From: Tim Townsend [REDACTED]
Sent: 18 May 2017 09:11
To: Planning.Responses
Cc: Claire Potts; Julie Bolton
Subject: Landscaping comments - LU/121/17/RES

Please find below, WSCC comments in response to landscaping for the above development. This should be read alongside previous WSCC highways response dated 15th May 2017.

Tree Planting Details LA108

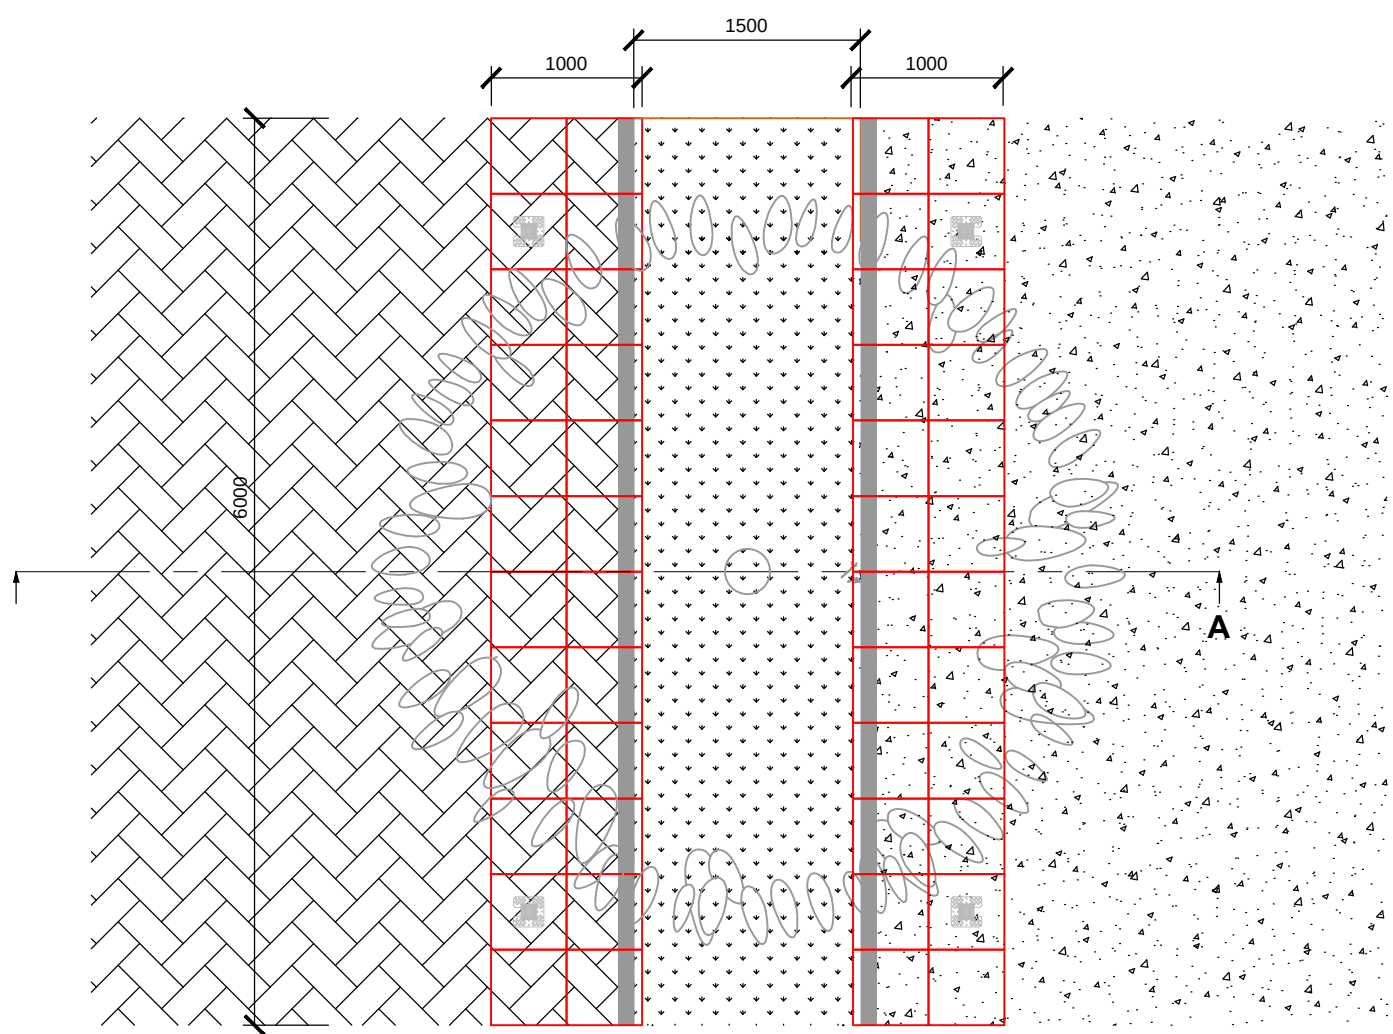
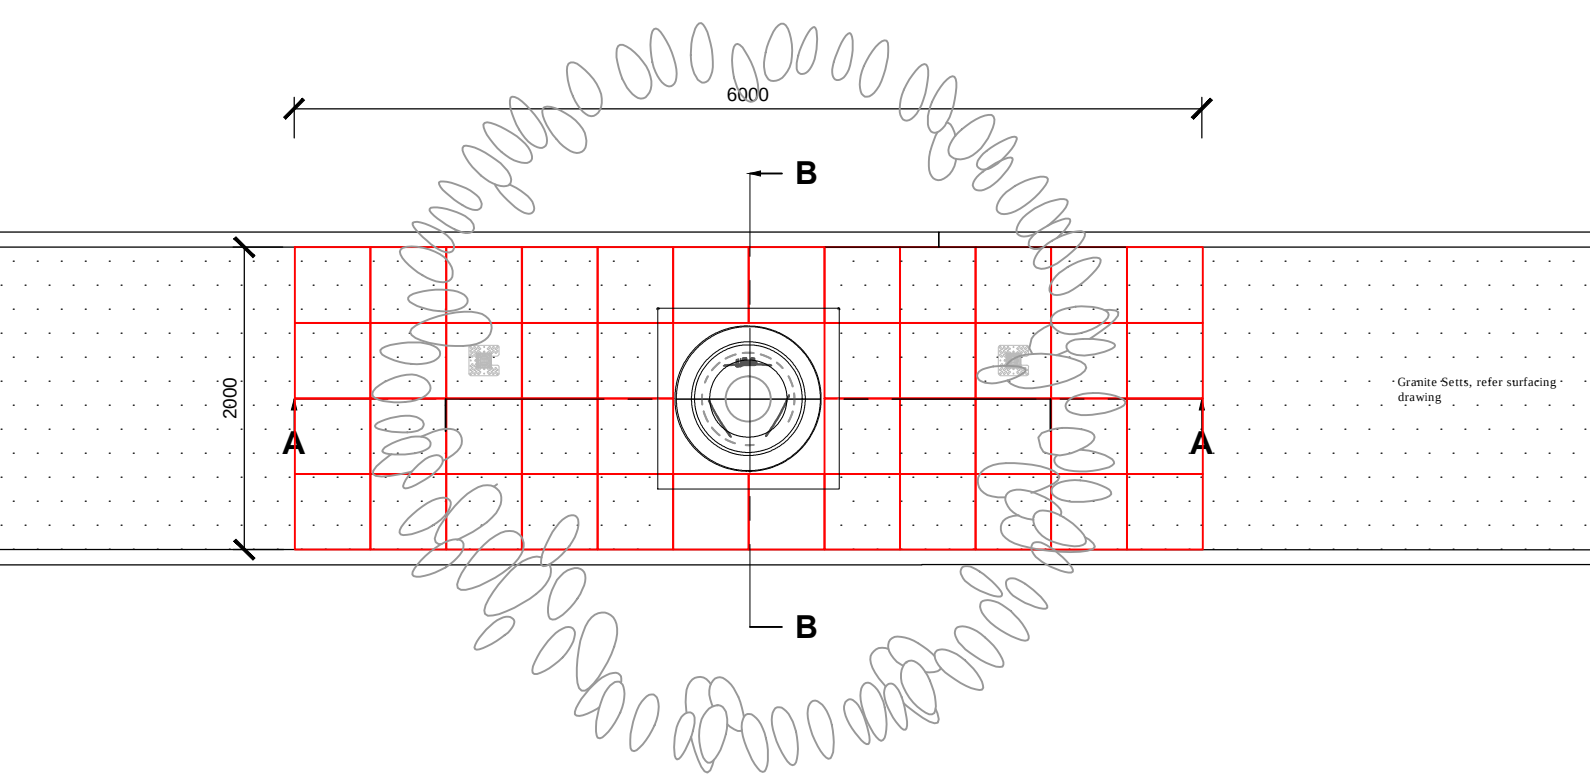
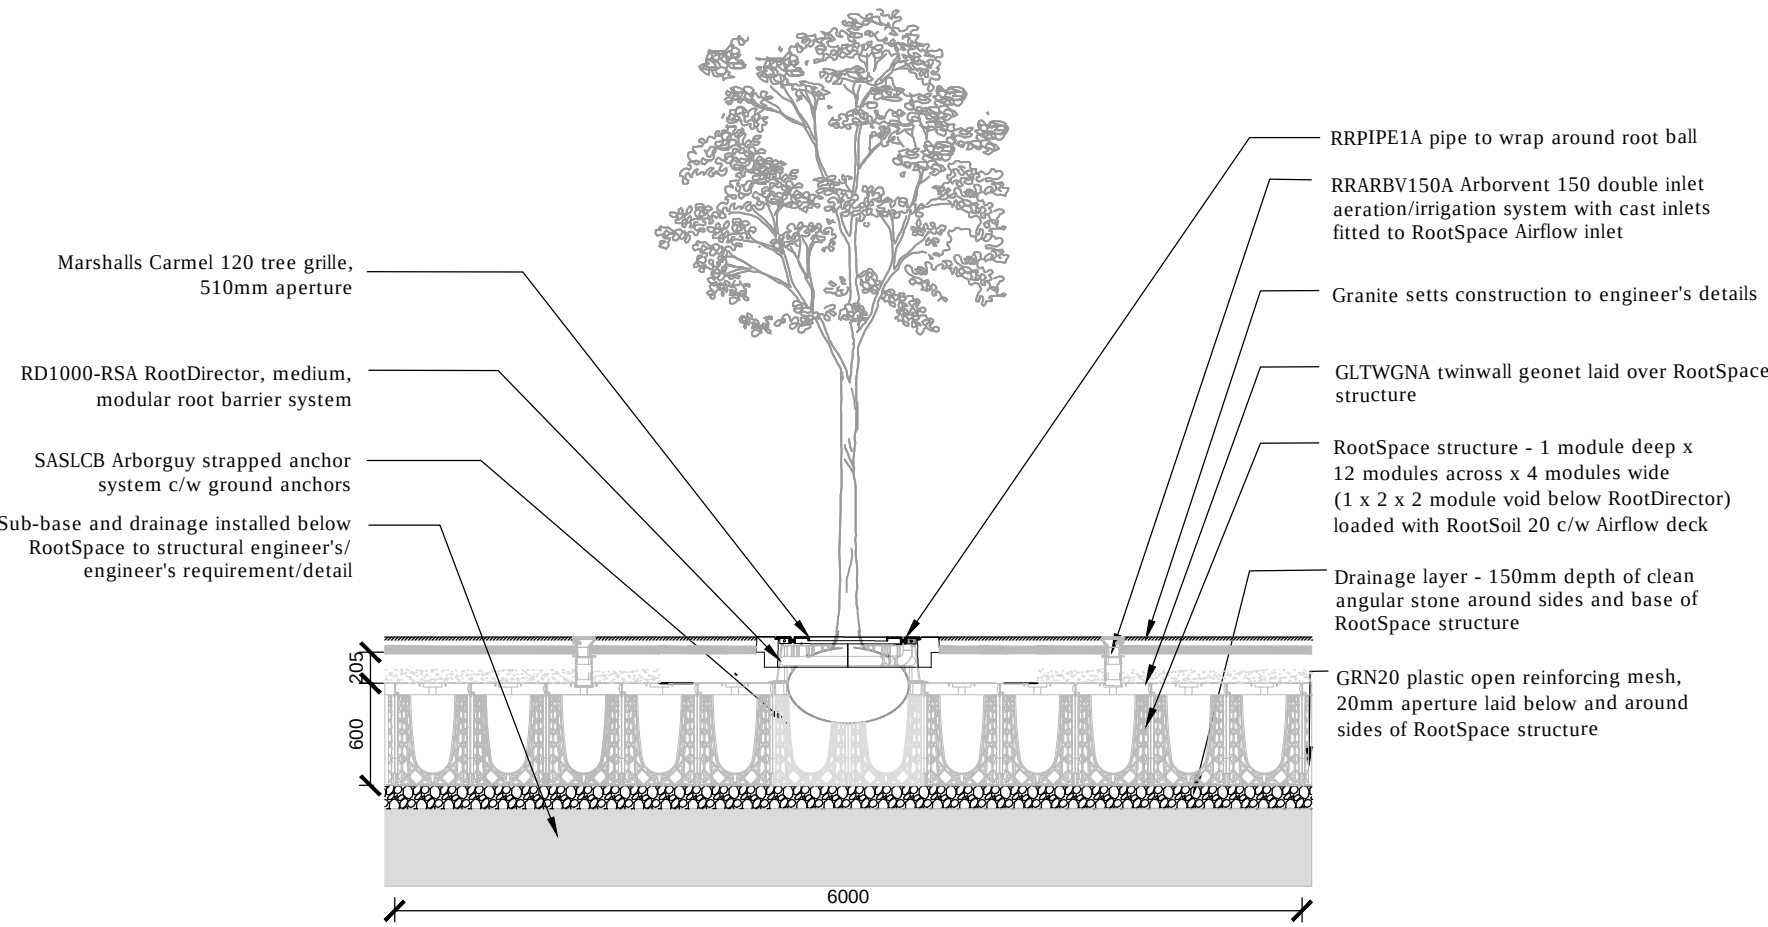
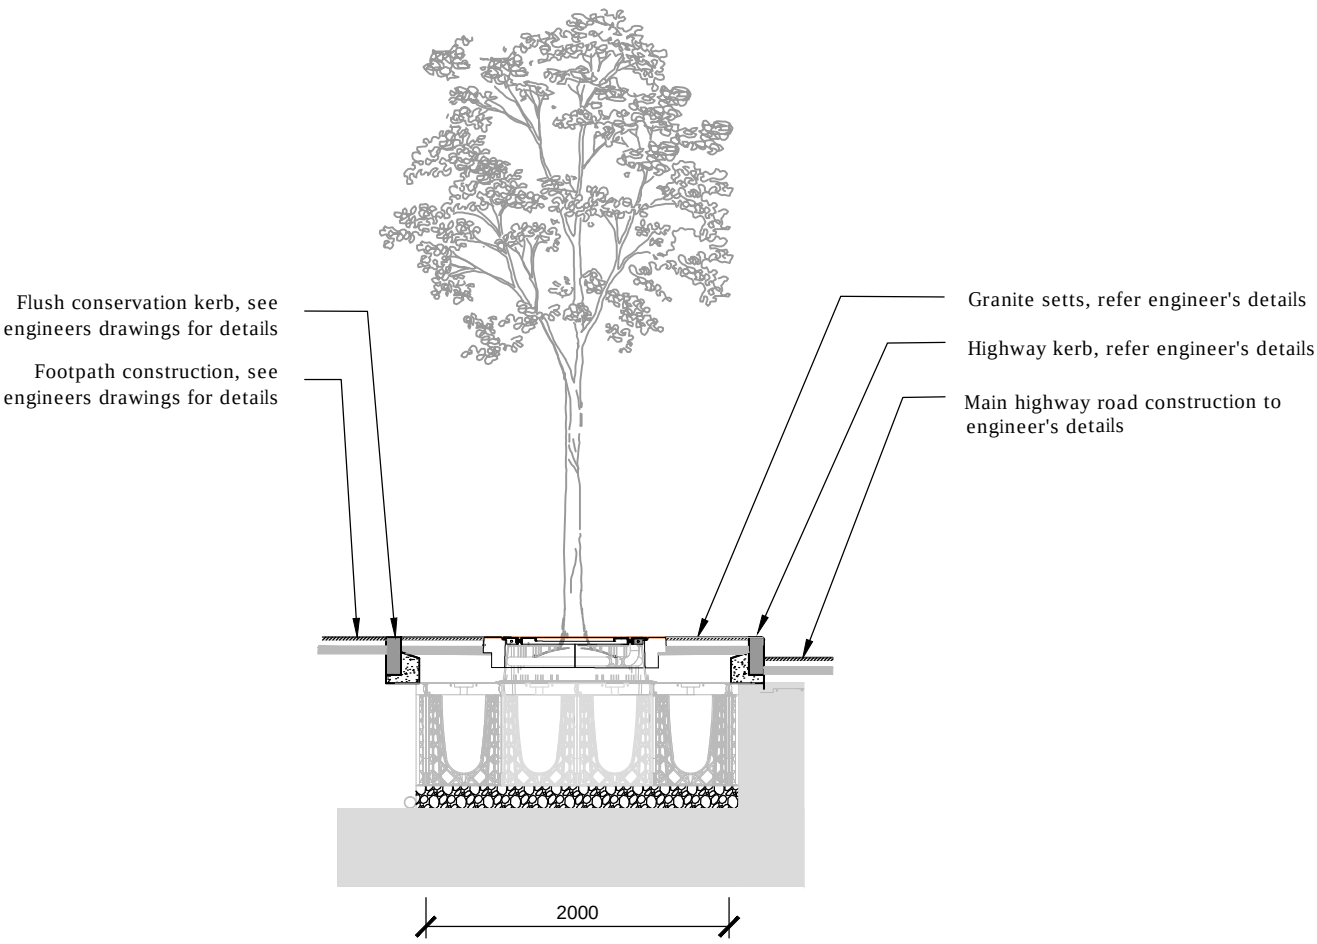
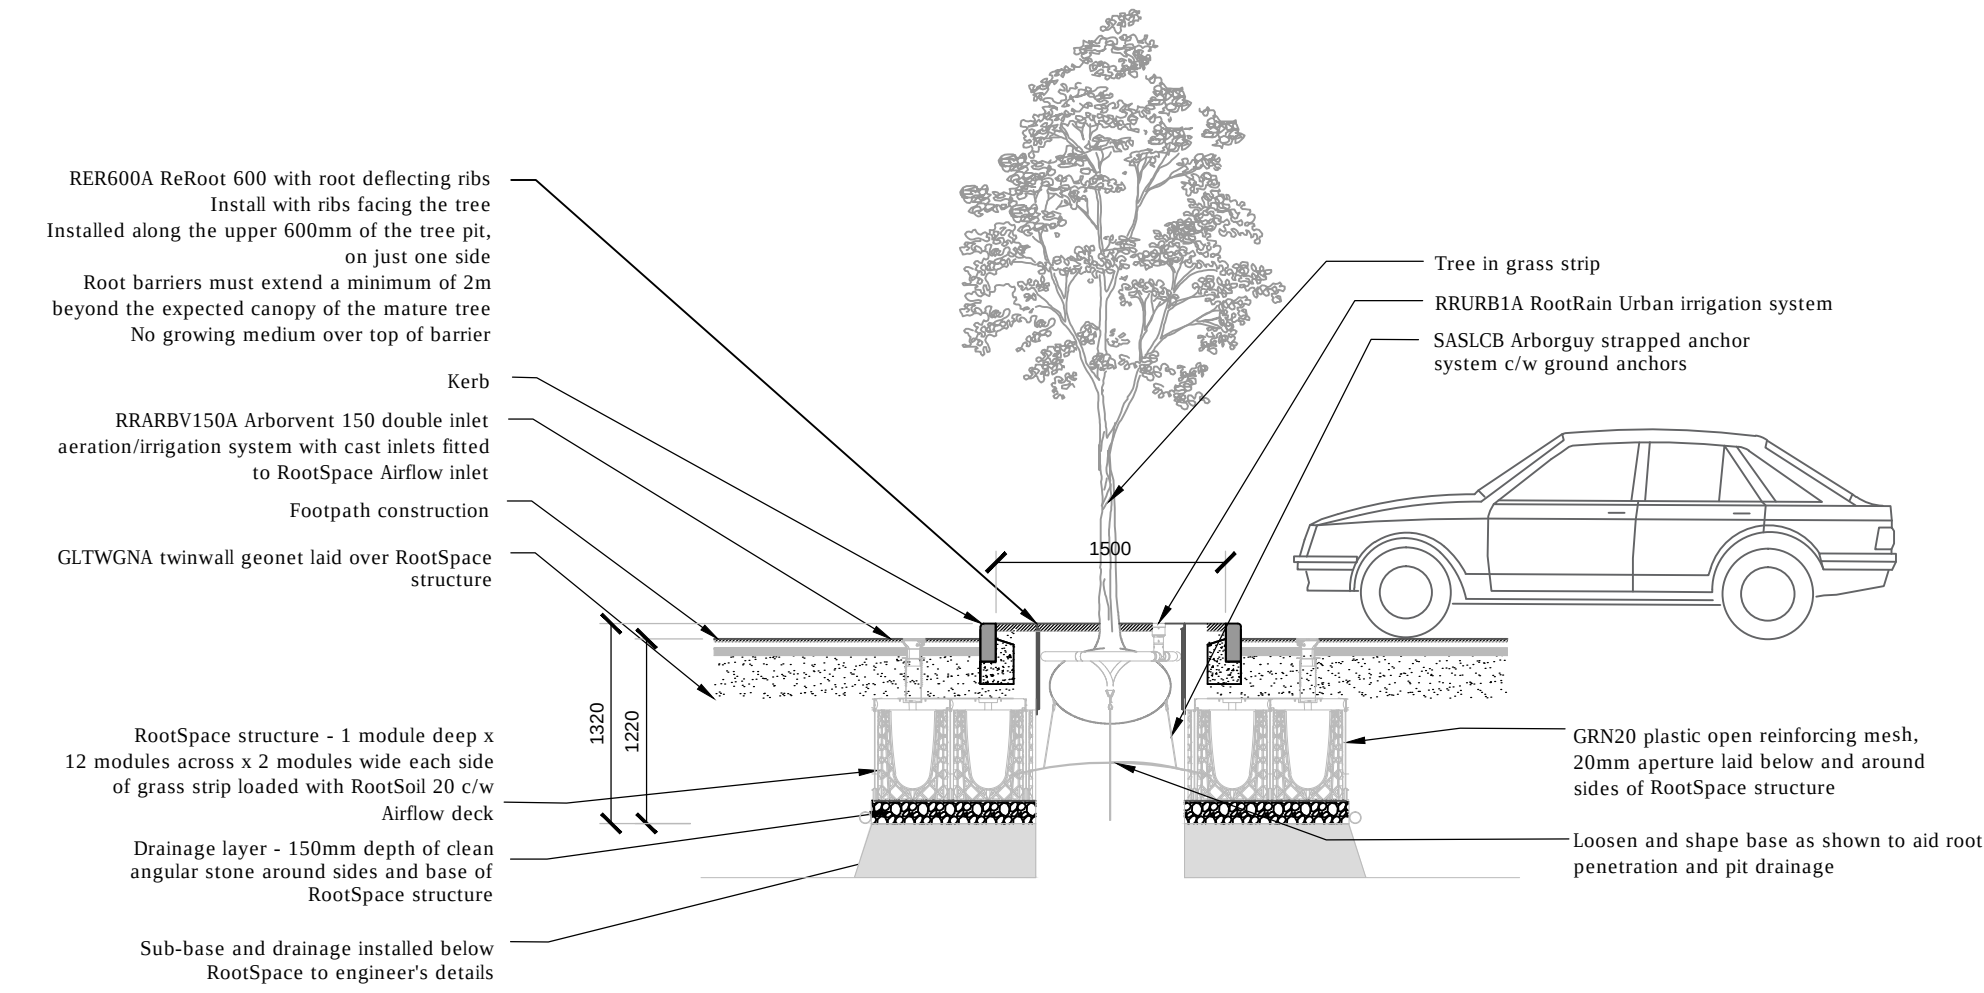
It is noted that to the south of 'Main Avenue', future development is likely to be 3 or 4 storey apartment blocks – this may preclude a continuous verge depending on access points, however, a continuous verge [or as continuous as possible] is far better for successful tree establishment / long term survival than individual planting locations. Ideally, the buildings should be set well back from the footway edge to give good separation between the building elevation / fenestration from trees, thus preventing future requests for removal / reduction. If there is a continuous verge, then there is no need for granite sett edging and tree grilles which will require maintenance and may become distorted through incremental growth or the grilles may damage the tree if left in situ for too long. Usually there are section / plan drawings showing the tree 'pit' details, e.g. irrigation system etc. Stakes / ties are indicated instead of ground anchors for trees of this size which is unusual/surprising – please explain.

Car park – the birches are shown in individual ‘pits’ with grilles and granite sett edging. It’s not clear what the surface is between each tree but if it is a hard surface only supporting low frequency pedestrian traffic, it should still be possible to have a continuous rooting environment underneath; soil cells may be needed to support the hard surface. Alternatively a continuous grass verge would be better – no need for grilles / edging. Will there be any bollards, knee rails or other ‘barrier’ to prevent cars damaging the tree stems? I note the trees are shown located between spaces but it is still possible.
